Please ask for: Ms Iqraa Malik
Email: iqraa.malik@terraquest.co.uk
Telephone: 0121 234 1390
Our Ref: BE/5/22/HH
Your Ref:
Date: 8th February 2022

Application for Planning Permission for Works or Extension to a Dwelling

Development: Retention of a rear Orangery
Location: 2 Old Moat Close Bersted PO22 9UP

PROPOSED Plan View

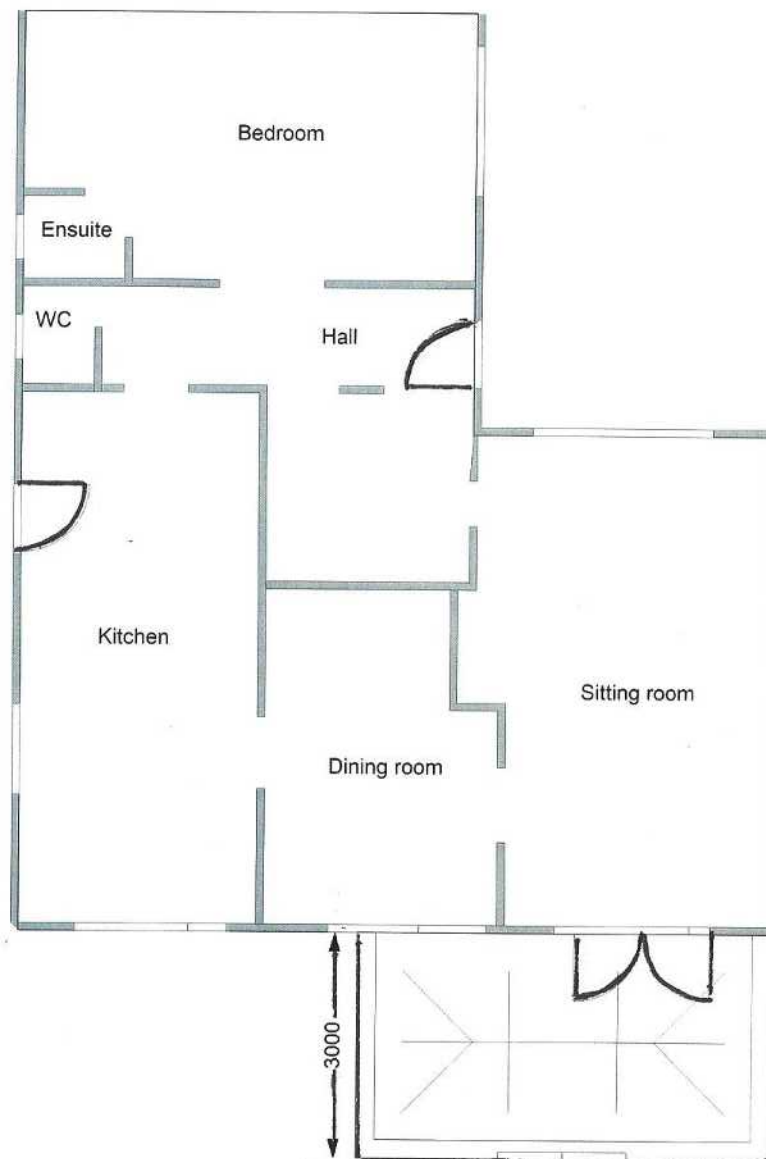
As these works have already taken place, the proposed floor plans must be labelled as existing rather than proposed. Please amend. Along with this, please submit pre-existing floor plans in PDF format at a scale of 1:50 or 1:100. Further details can be found in the Validation Requirements List.

PROPOSED Right Elevation

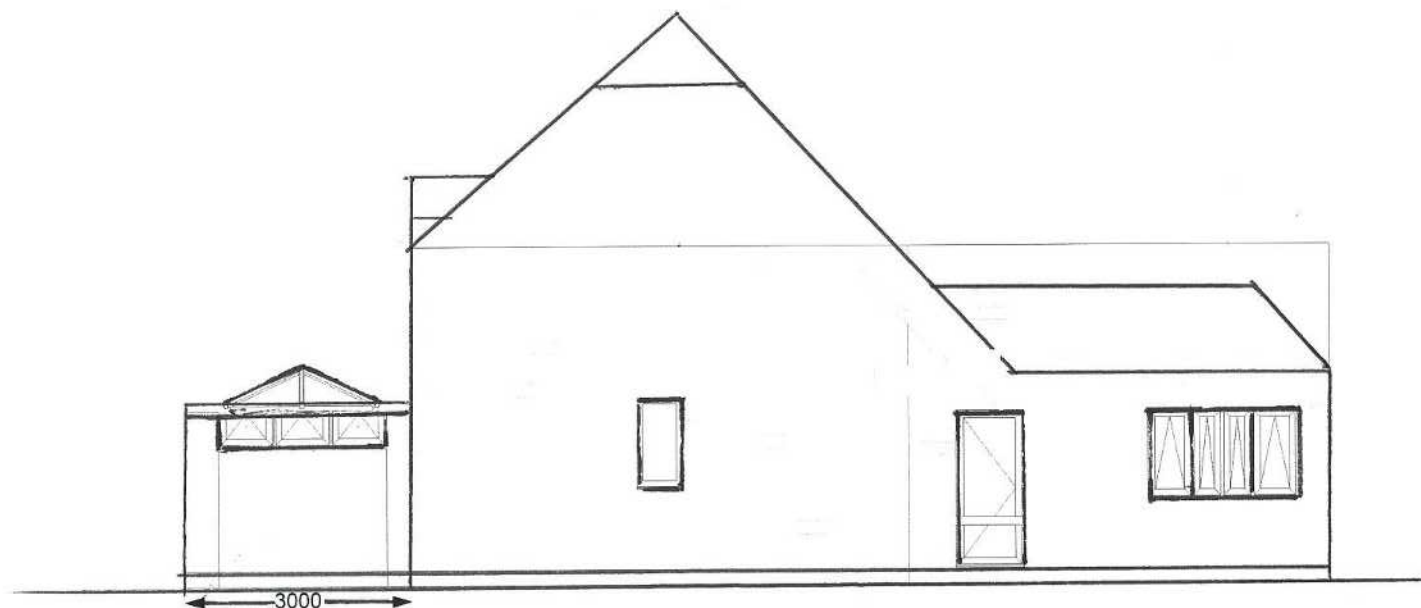
As these works have already taken place, the proposed elevations must be labelled as existing rather than proposed. Please amend. Along with this, please submit pre-existing elevations in PDF format at a scale of 1:50 or 1:100. Further details can be found in the Validation Requirements List.

20 OLD MOAT CLOSE, STIRIPNEY, WEST SUSSEX, PO22 9UR

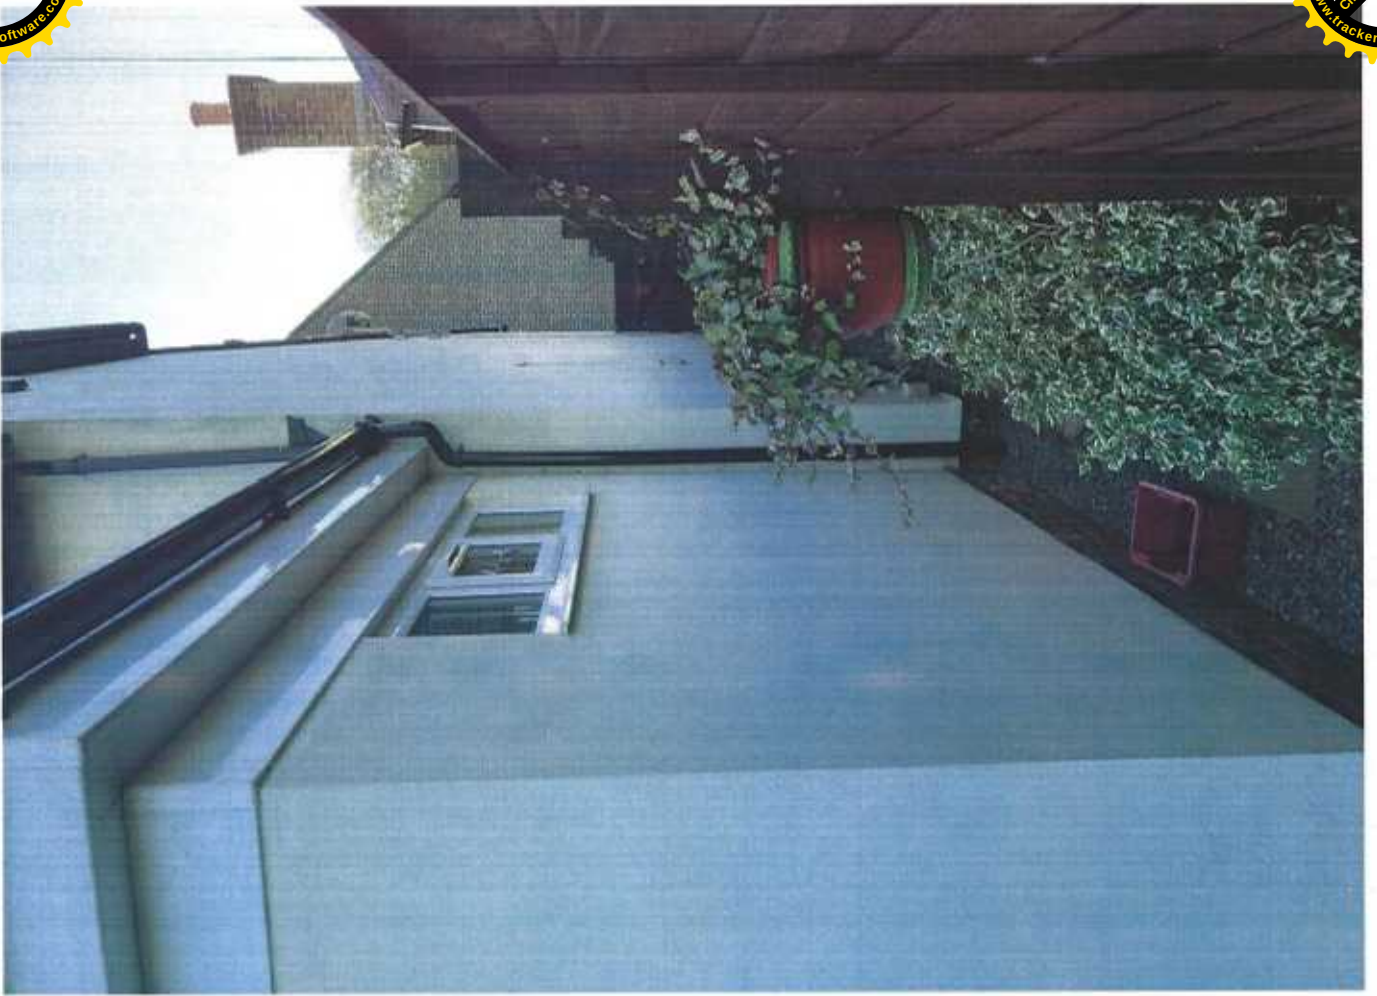
The block plan requires dimensions from the proposed extension to all site boundaries in pdf format at a scale of 1:500. Please amend. Further details of what must be included on the plan can be found in the Validation Requirements List.
